Arun District Council
Arun Civic Centre
Maltravers Road
Littlehampton
West Sussex BN17 5LF
Planning & Building Control General
Enquiries

**The Town and Country Planning Act 1990 (as amended)
Town and Country Planning Development Management Procedure Order 2010 (as amended)**

**Replacement dwelling
44 Broadmark Lane Rustington**

DRW NO 8a SCALE 1/1250
LOCATION PLAN

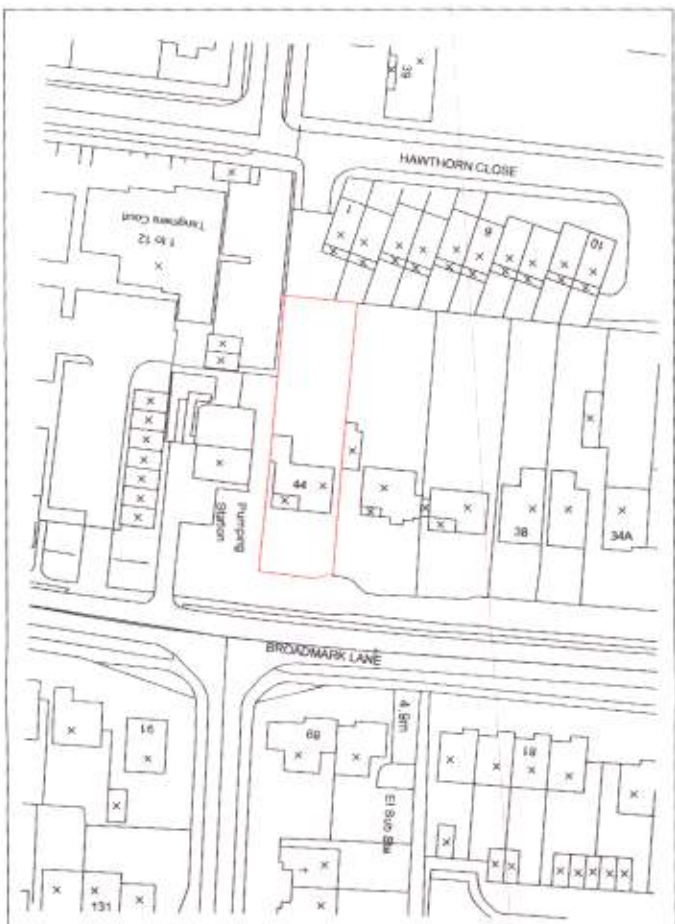
I require 1 electronic or 3 paper copies of a revised location plan showing Broadmark Lane as a named road.

Michael Pearce & Associates Ltd Chartered Surveyors - Architectural Consultants 3 West Ridings, East Preston, West Sussex. BN16 2TD	Tel 01903 786839 Mob 07812 195560 e-mail:michael@mpa-surveyors.co.uk	NEW DWELLING 44 BROADMARK LANE, RUSTINGTON	DRW NO 7a SCALE 1/500 SITE PLAN
--	--	---	---	--

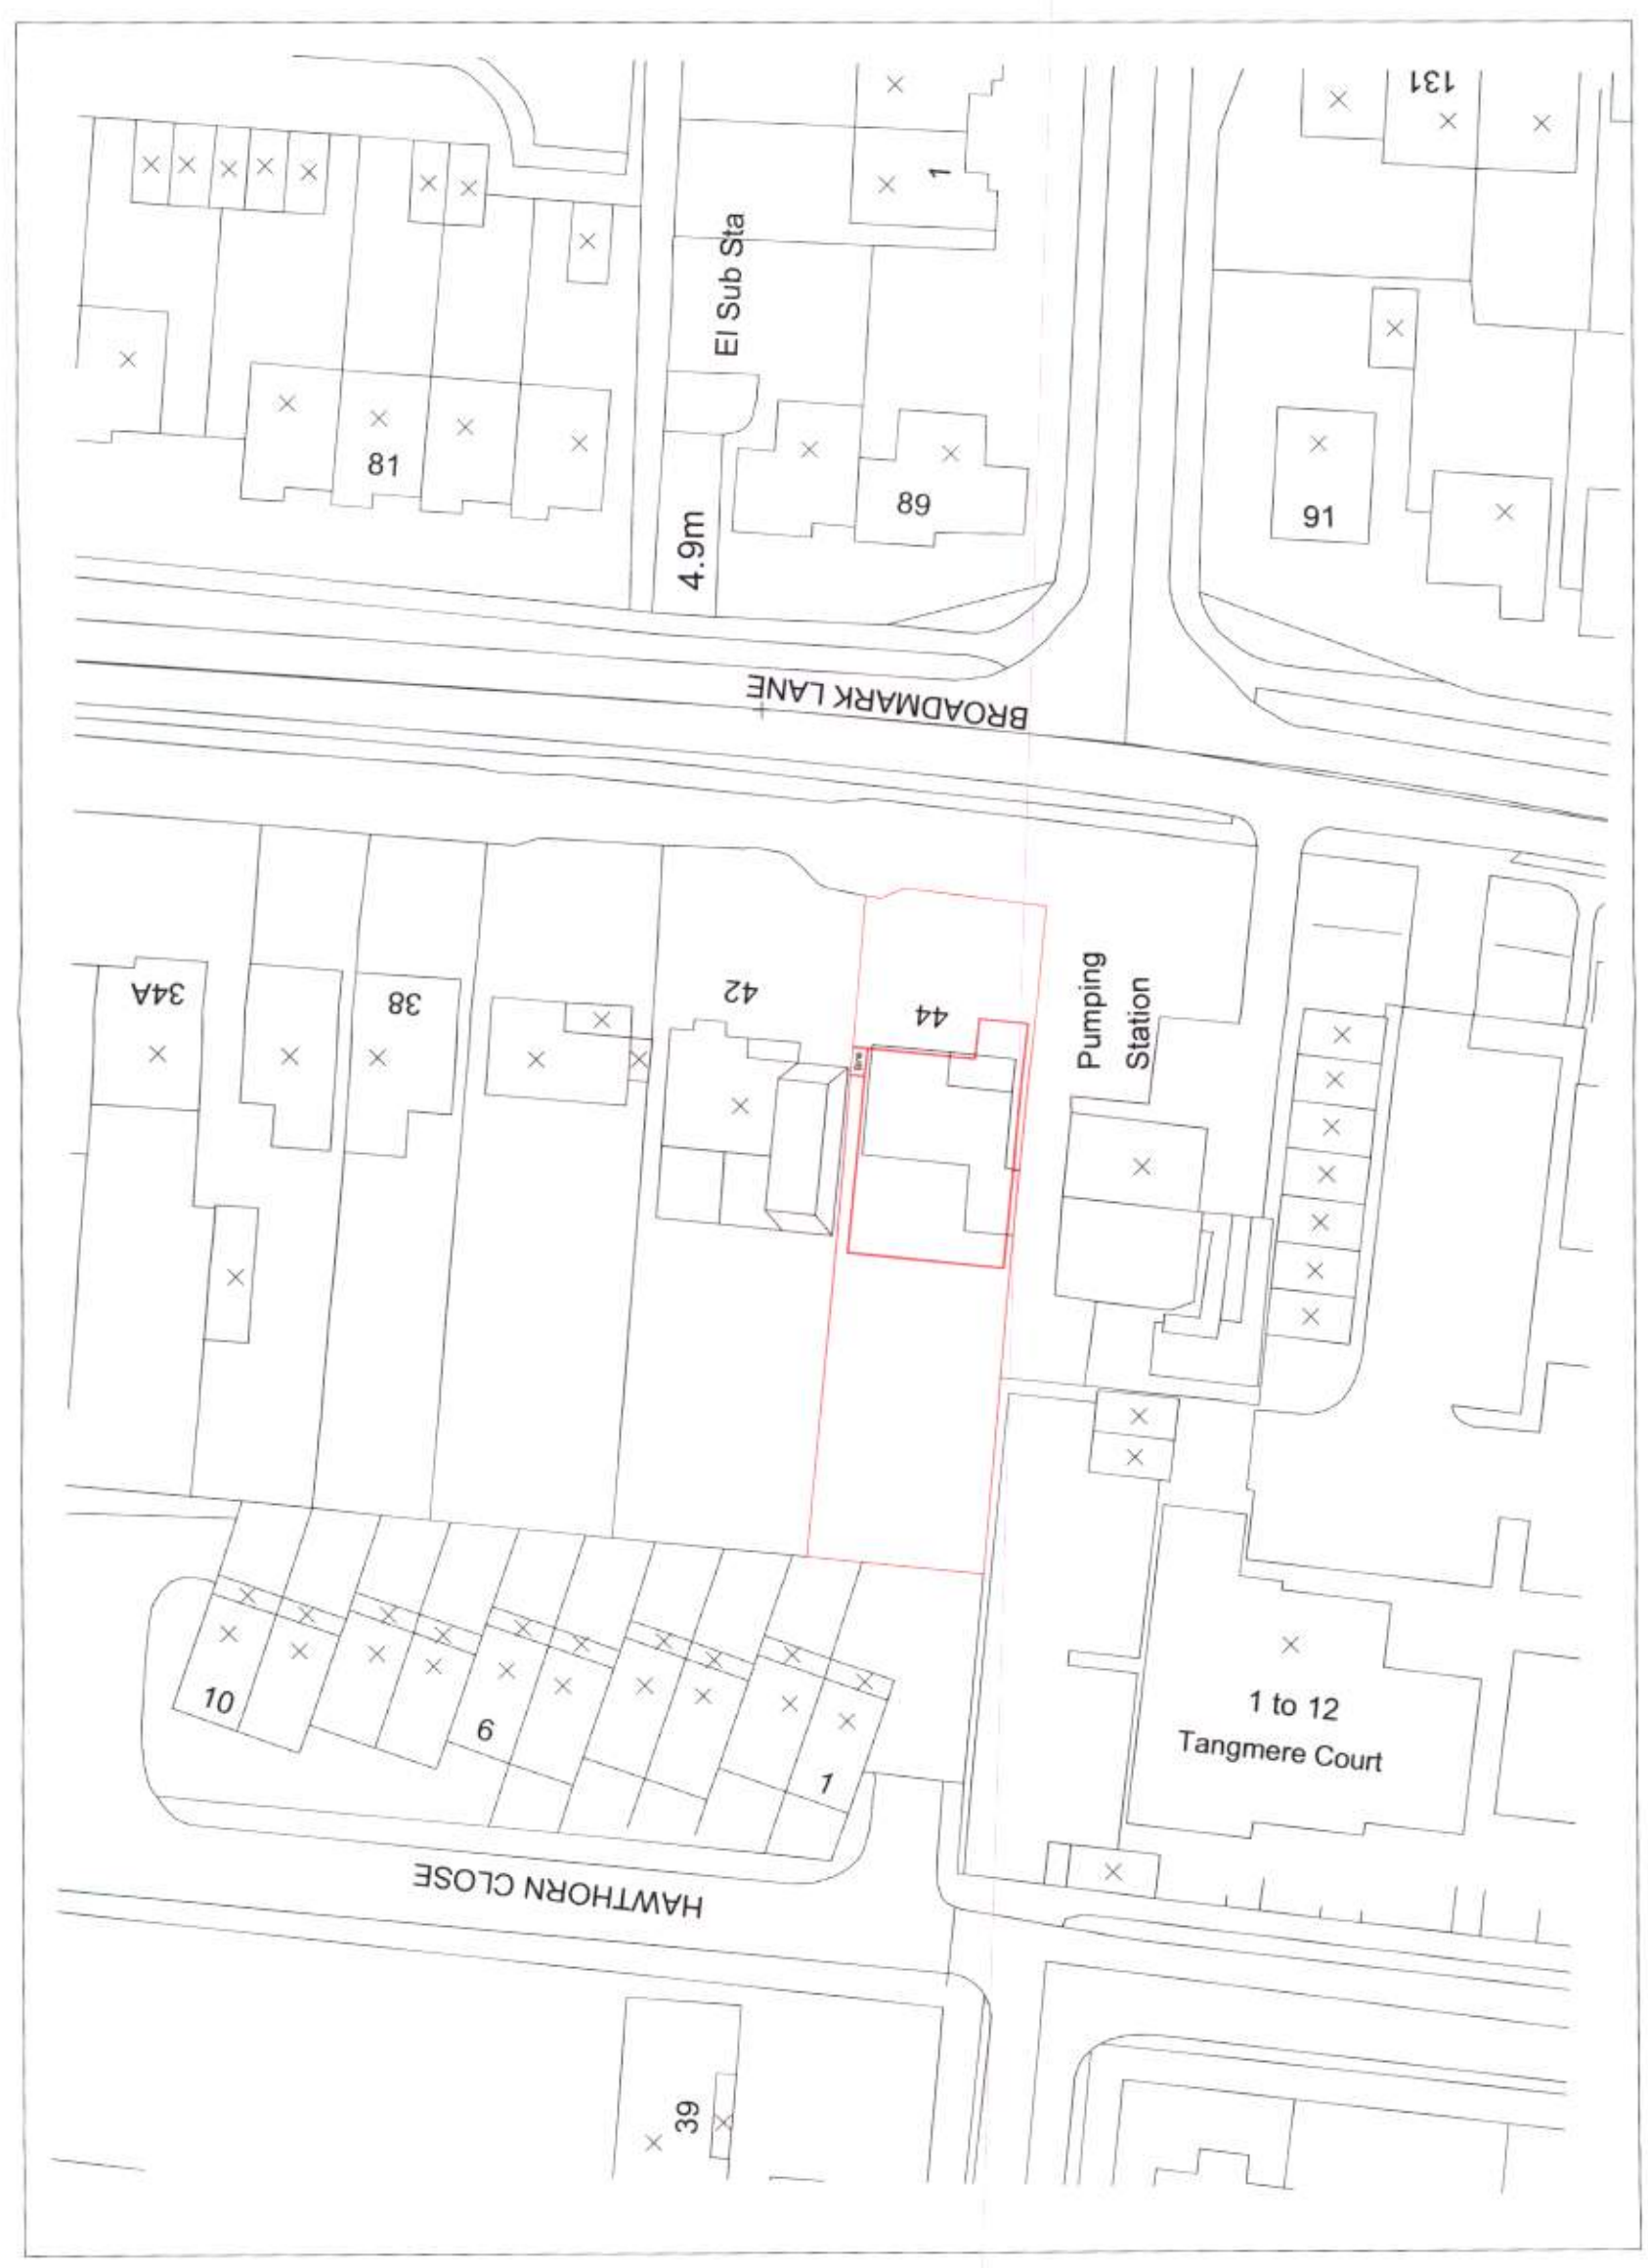
I require 1 electronic or 3 paper copies of a revised block/site plan showing the footprint of the existing dwelling marked as a dotted line and the waste storage and collection arrangements (as stated in the application form).

DRW NO 2a SCALE 1/50
 PROPOSED FIRST FLOOR PLAN

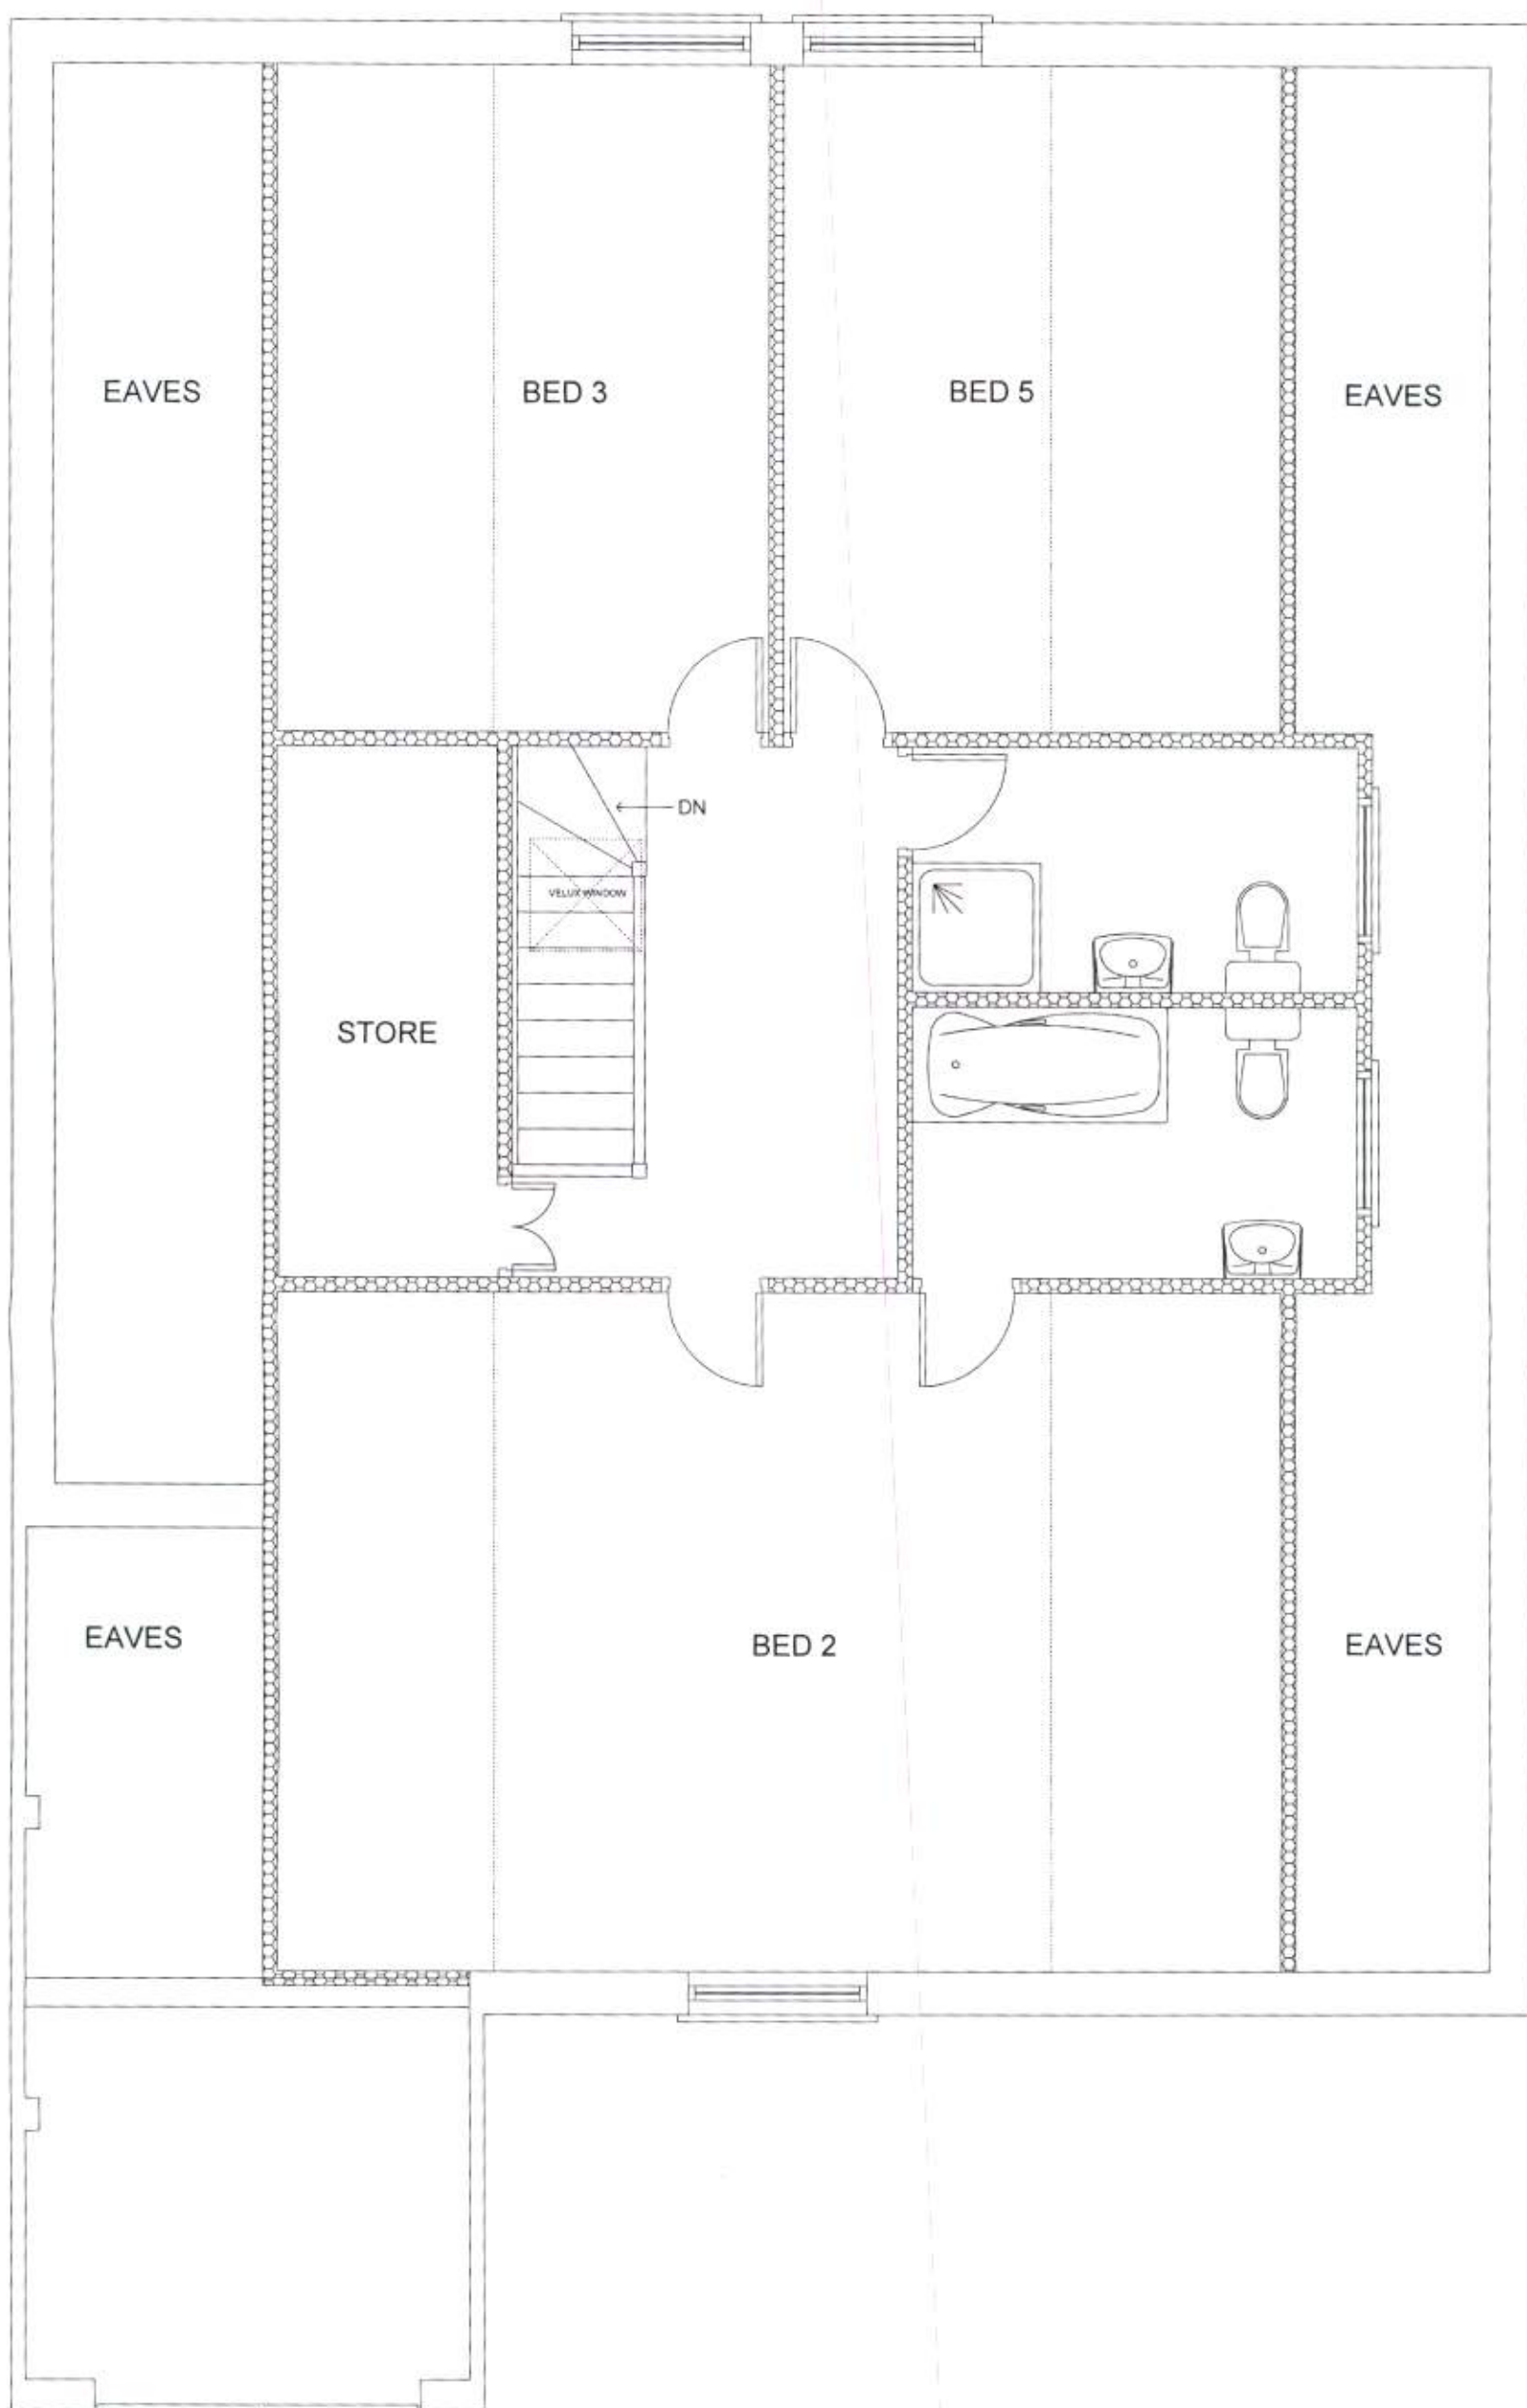
Please provide 1 electronic or 3 paper copies of a revised first floor proposed floor plan to show the velux window on the side elevation (south).
